Application by National Grid Electricity Transmission (NGET) for an Order Granting Development Consent for the Yorkshire Green Energy Enablement (GREEN) Project

Request for Further Information

2. Access off A659 at Tadcaster

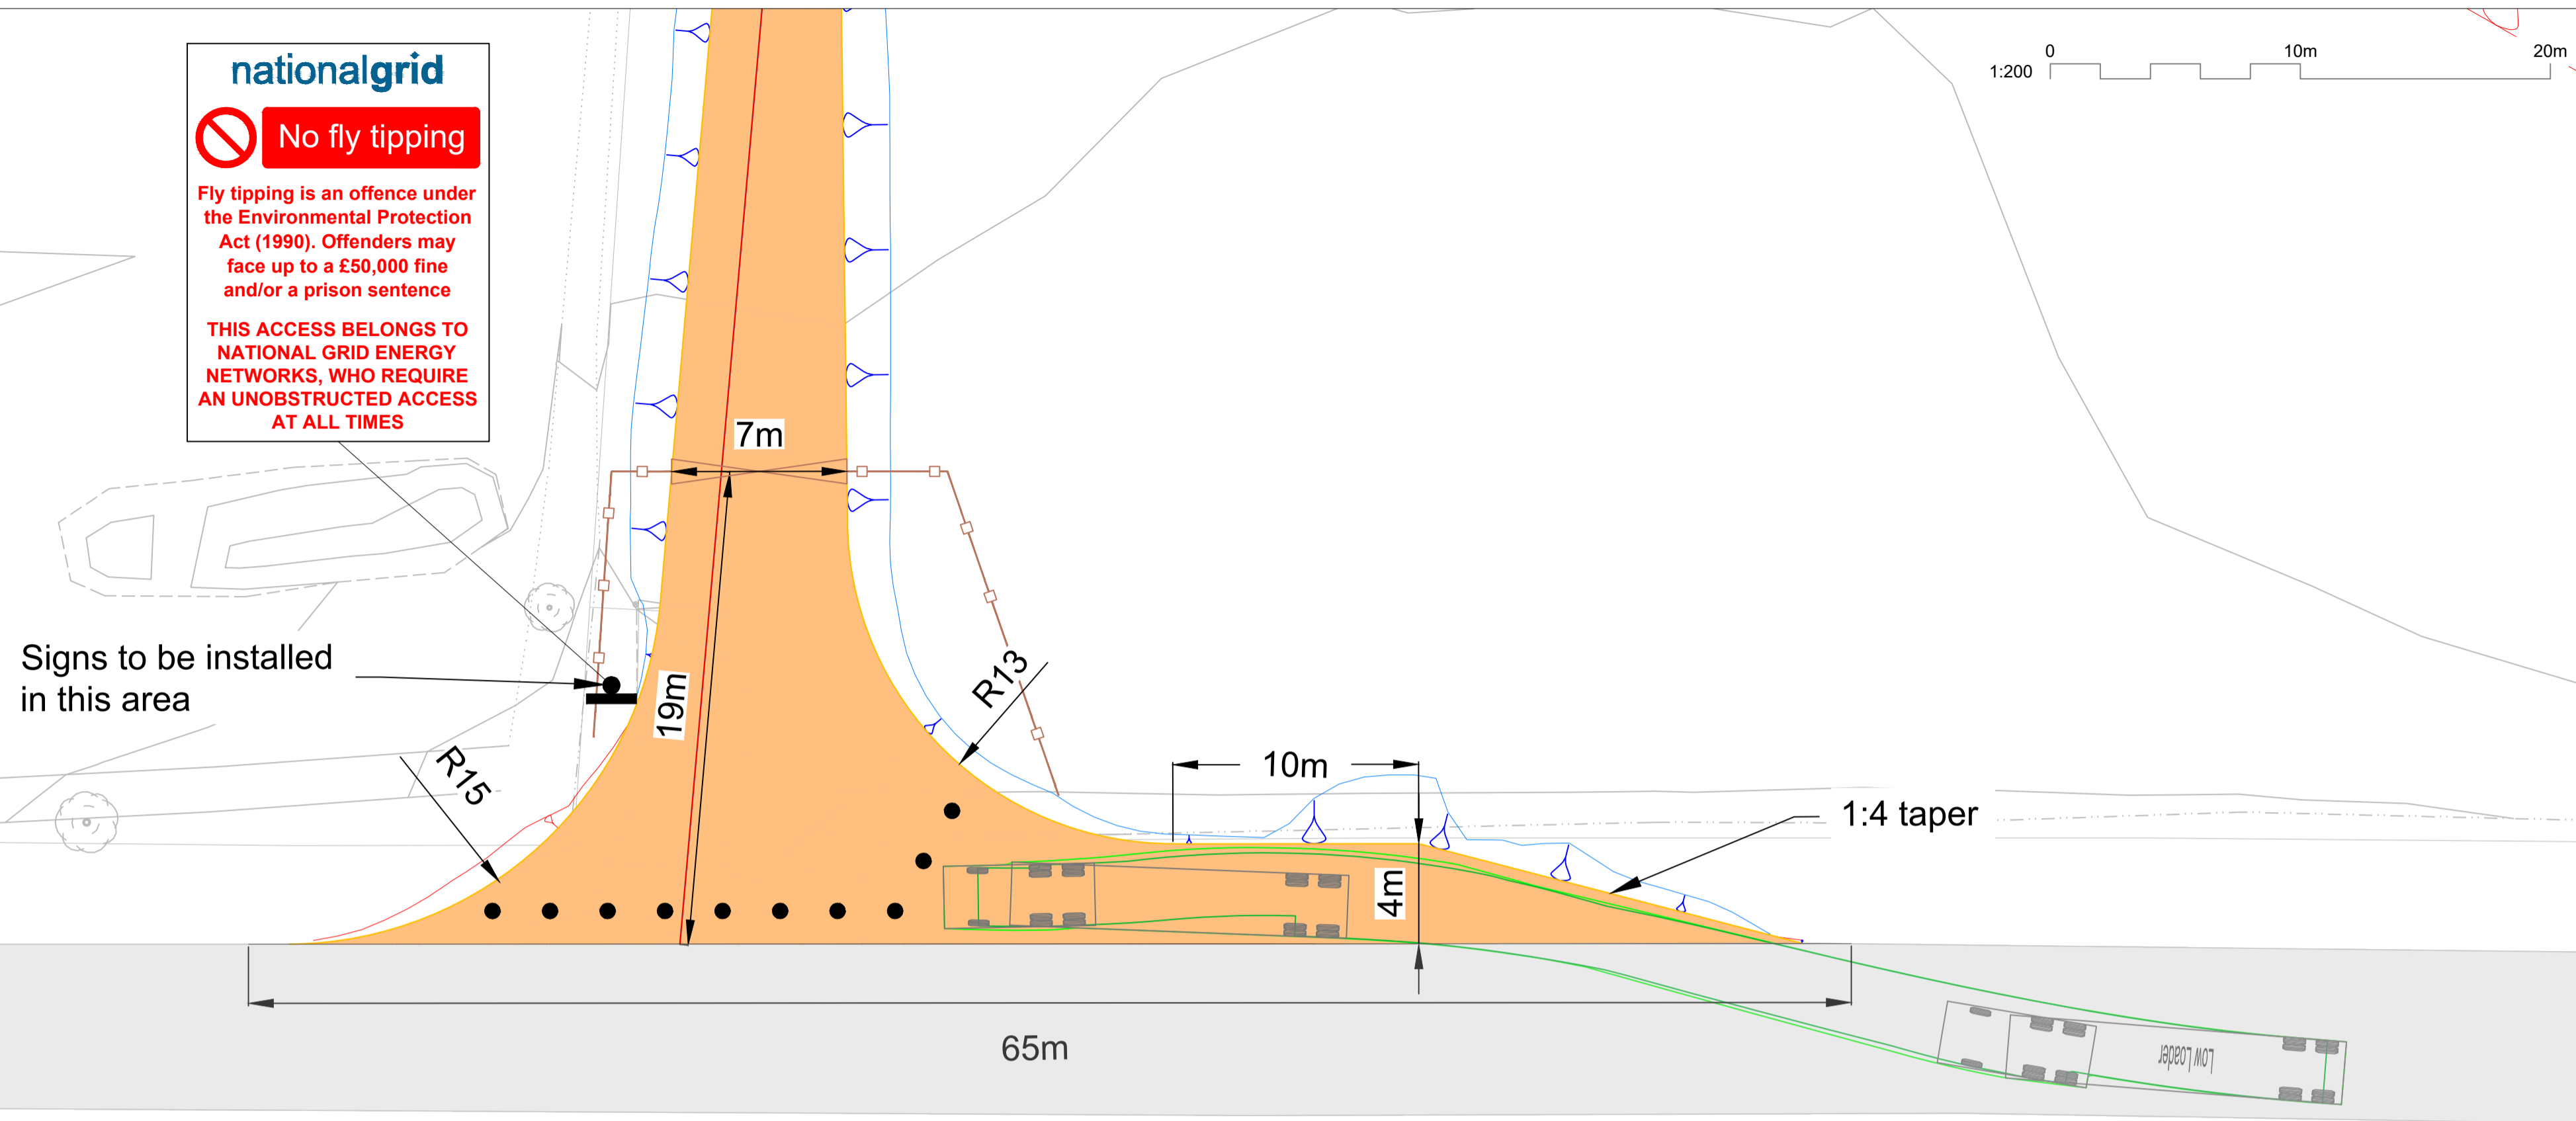
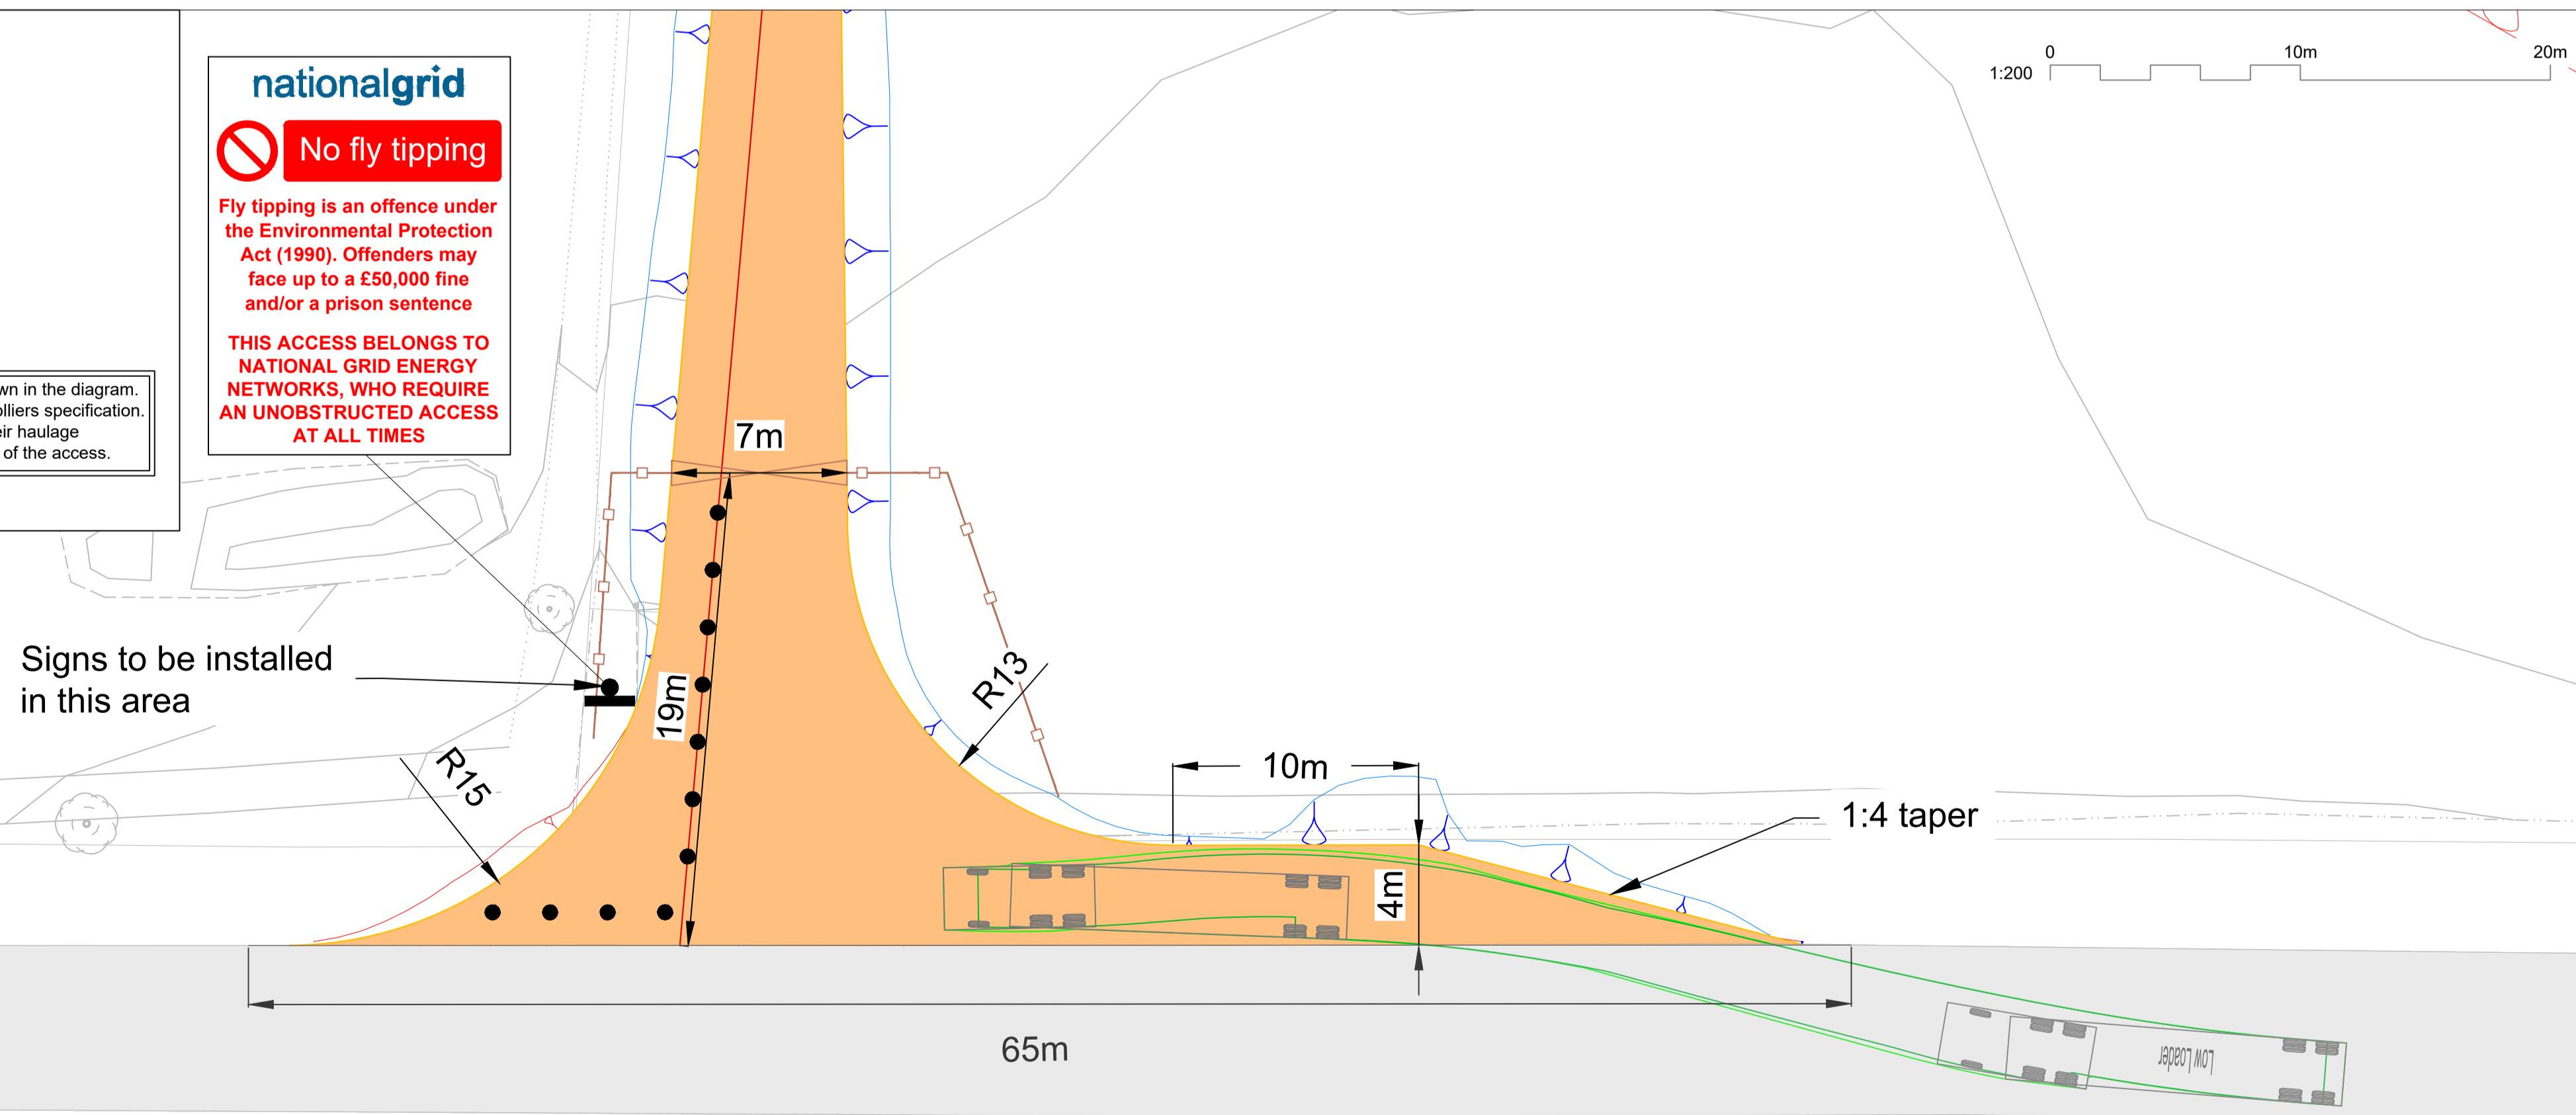
- Following discussion at Compulsory Acquisition Hearing (CAH) 2 [EV-008b] and [REP6-059], it is the ExA's understanding that the Applicant had agreed that the access track to the proposed West Cable Sealing End Compound along the north eastern boundary of Mr Watson's land (with that in the ownership of Samuel Smith Old Brewery) could be accommodated at a width of 4 metres. The illustrative plan set out in Appendix A of the Applicant's Deadline 7 submission '[Document 8.29.5](#):

Applicant's Deadline 7 Response to Compulsory Acquisition Hearing 2 (CAH2)
Action Points' shows this with a width of 7 metres.

- Explain why a track of 7 metres width is shown on the illustrative plan;
- If it remains the Applicant's position that a track with a width of 4 metres could be accommodated, submit a version of the illustrative plan that shows this; and
- For the avoidance of doubt, confirm whether the reference to the A361 in the title of Appendix A should instead be to the A659.
